CITY OF ALBUQUERQUE

**Planning Department
Transportation Development Services Section**

Re: Certification Submittal for Final Building Certificate of Occupancy for
Del Norte Office Park, [G-18 / D4]
5310 Homestead Road NE
Engineer's Stamp Dated 08/30/07

**Re: Del Norte Office Park, 5310 Homestead Rd. NE,
Approval of Permanent Certificate of Occupancy (C.O.)
Engineer's Stamp dated 10/24/06 (G-18/D004)
Certification dated 08/30/07**

## PRELIMINARY GRADING PLAN HOMESTEAD OFFICE PARK

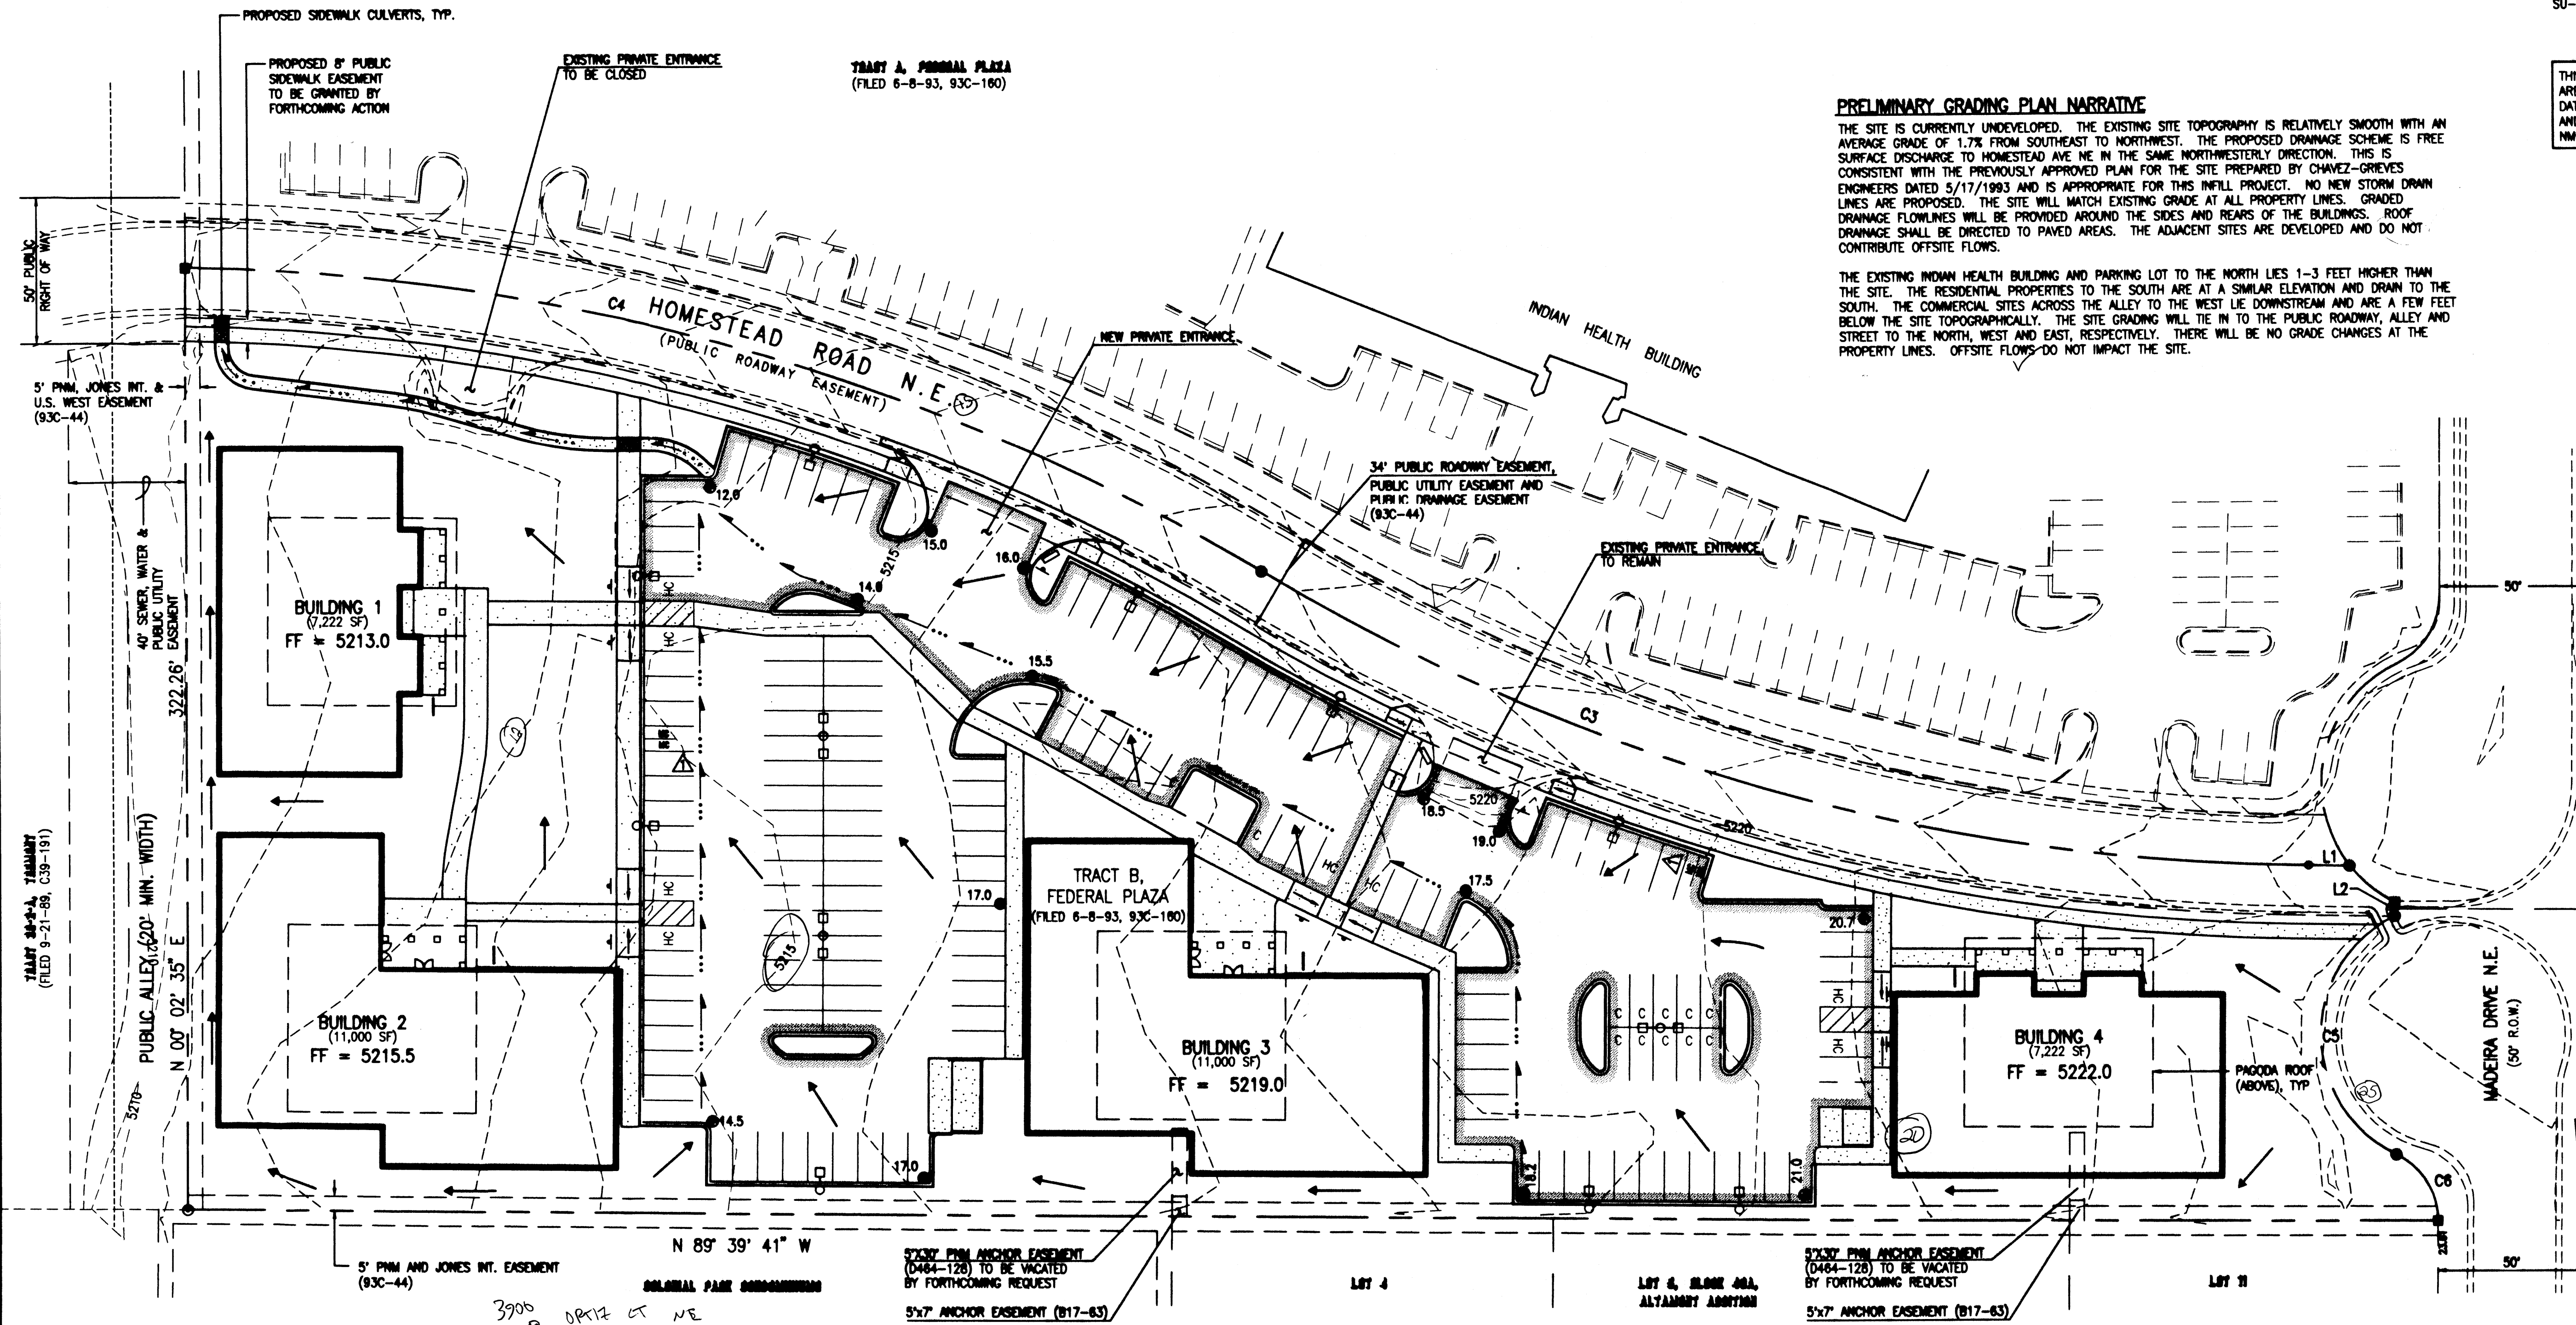
The site plan approved by the DRB showed the drainage on the south side of the site turning north at the southwest corner and draining through a sidewalk culvert to Homestead Road. The plan submitted does not comply with this. It shows the runoff from the south side draining into the alley and the area in the northwest corner draining over the sidewalk or into the dirt area next to the alley. The direction of the roof flows is unclear, which could exaggerate this condition.

The concept submitted for Site Development Plan should be adhered to. Runoff from the south side and from the concrete swale should enter Homestead Road via a sidewalk culvert. The runoff along the south side could be conveyed to Homestead Road via a swale or similar and the concrete swale should be extended west to pickup the runoff mentioned above as well as the runoff from the landscaping area in the northwest corner.

Transmitted herewith are the above listed items that include the build notes and details for the sidewalk culverts and concrete rundown that you asked me to provide as a condition of grading plan approval. These plans immediately precede the grading plan in the overall permit set and have the same stamp date. Per our discussion, I believe this should address your comment letter and you will be able to issue an approval for the grading plan.
